CORRECTED CONDOMINIUM MAP OF HIGH ALTITUDE AERO HANGAR CONDOMINIUMS

A PORTION OF THE NORTHWEST QUARTER OF SECTION 4
TOWNSHIP 13 SOUTH, RANGE 64 WEST OF THE 6TH P.M.
COUNTY OF EL PASO, COLORADO

Info Only: Engineering comments are in blue text.

PCD File No. SF2414

# CORRECTED CONDOMINIUM MAP OF HIGH ALTITUDE AERO HANGAR CONDOMINIUMS

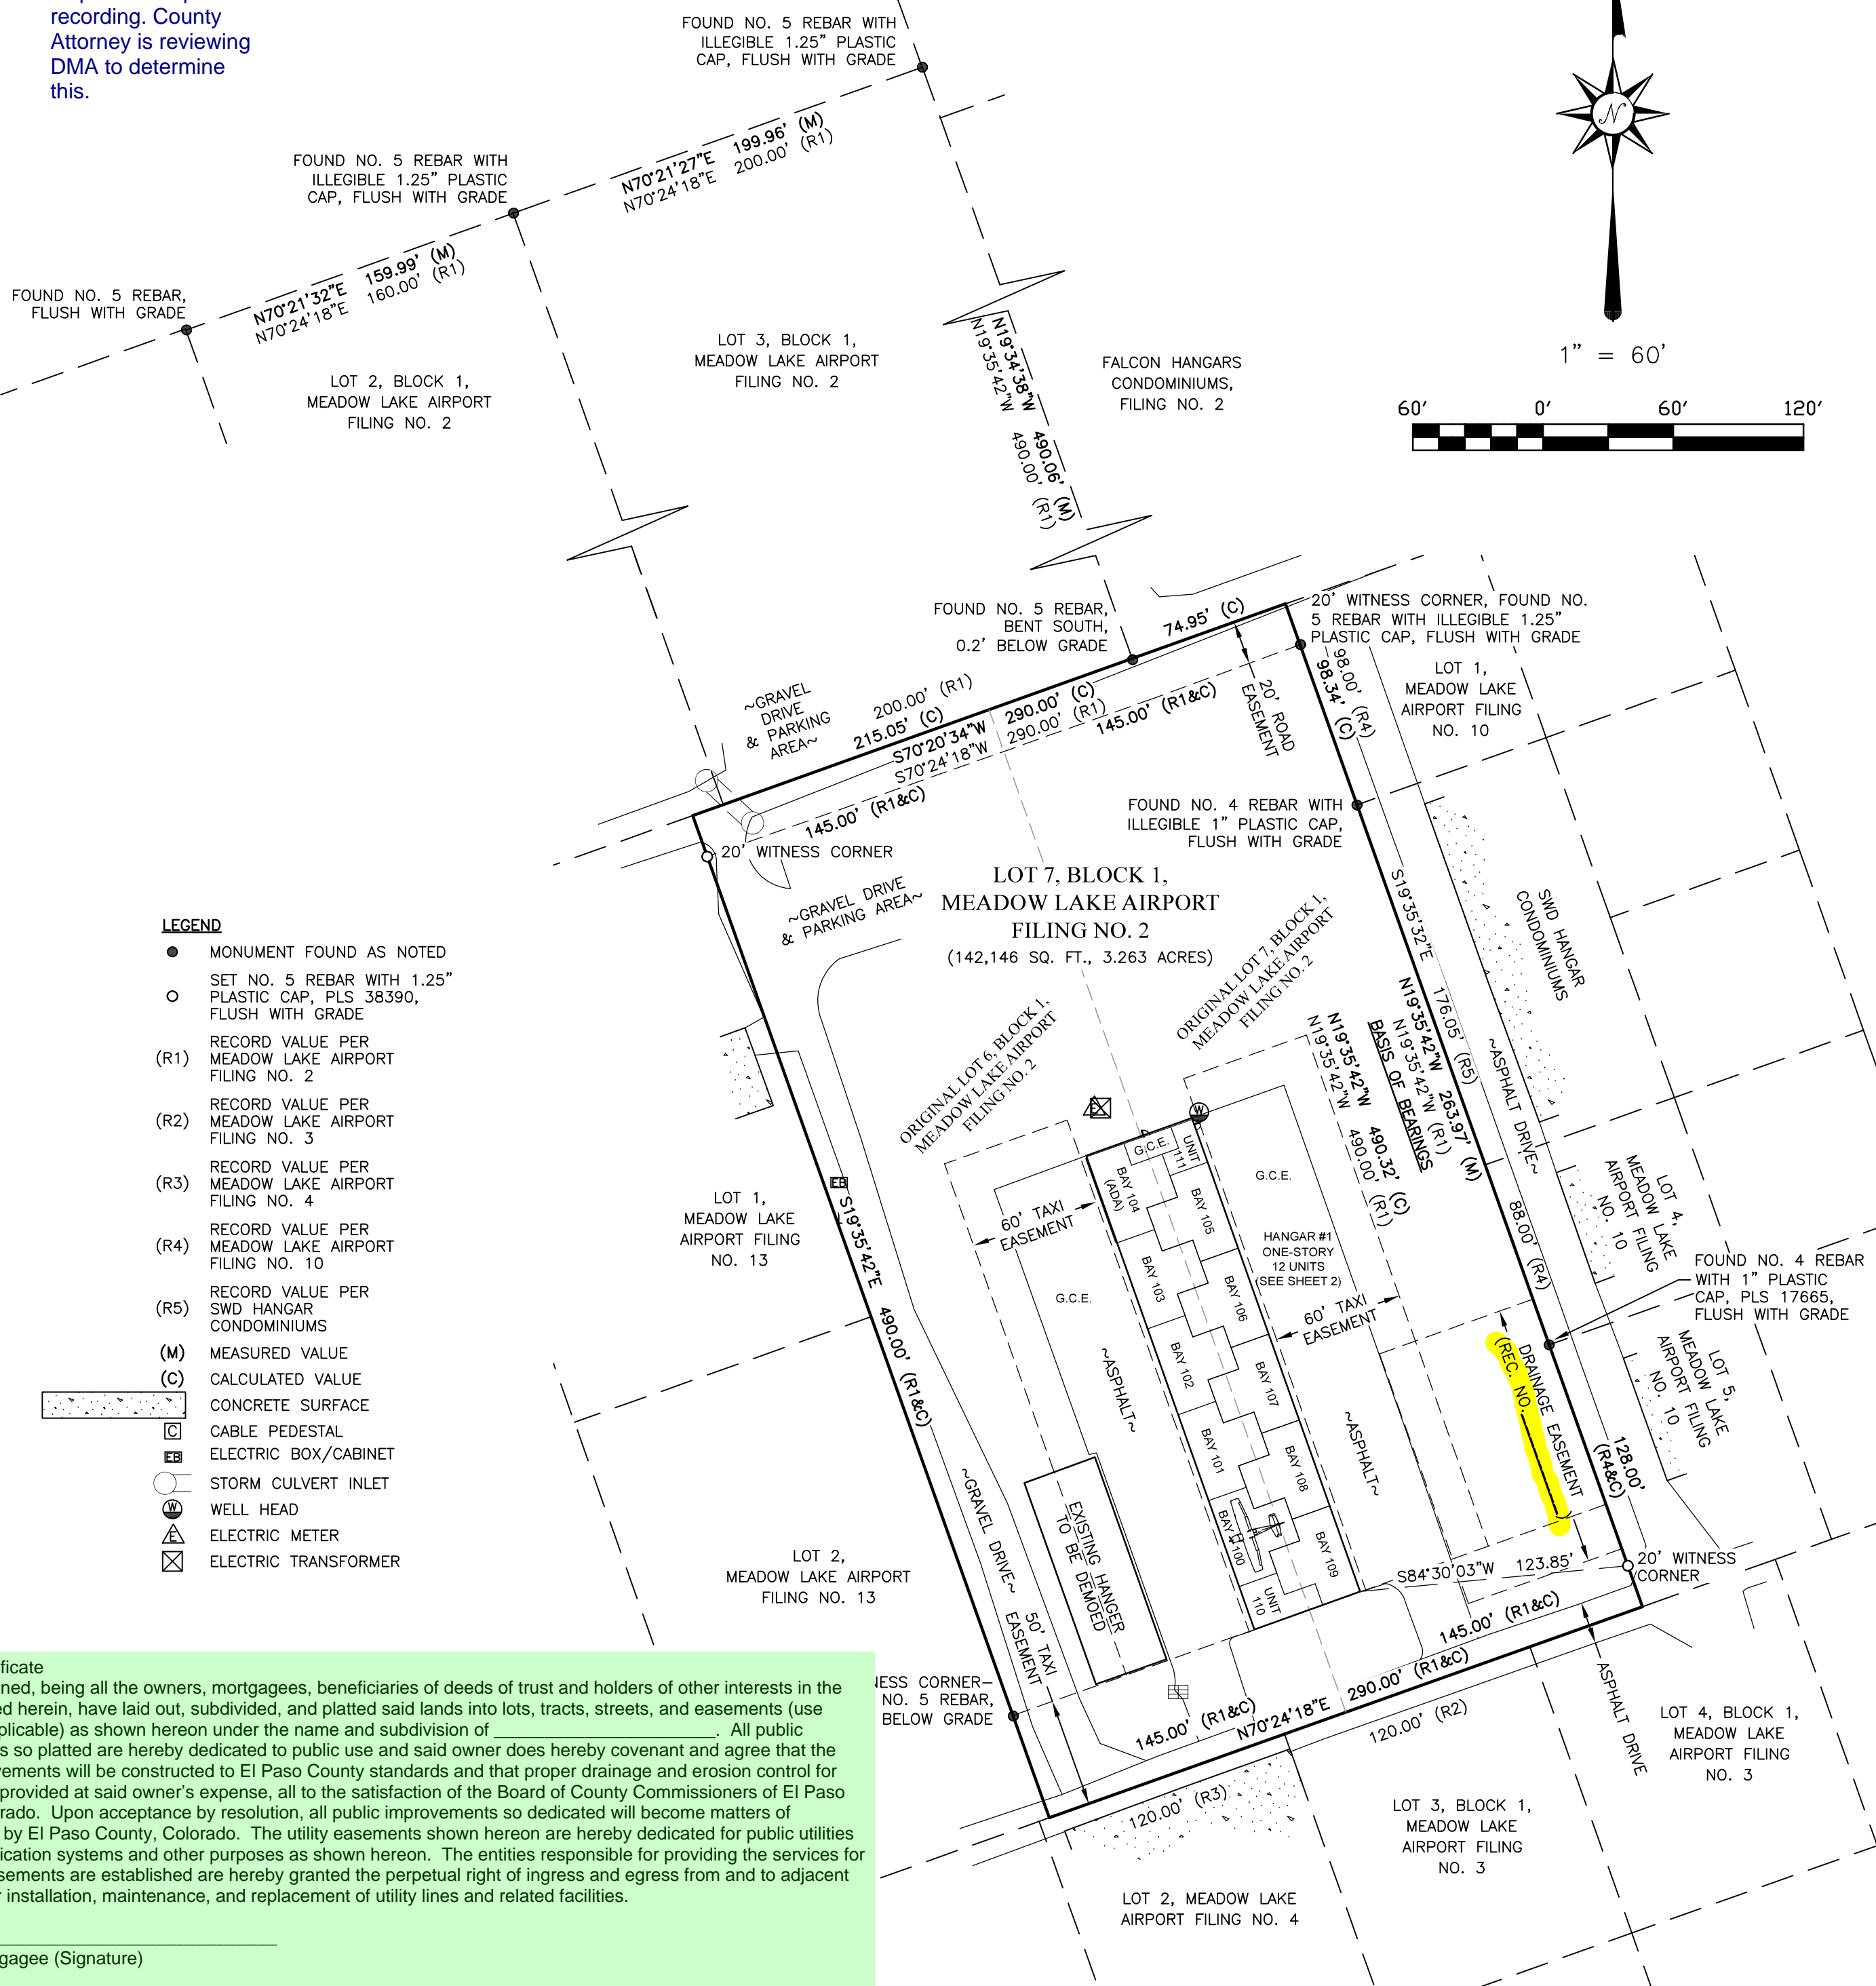
show drainage easement for the pond identified in the site development plan application.
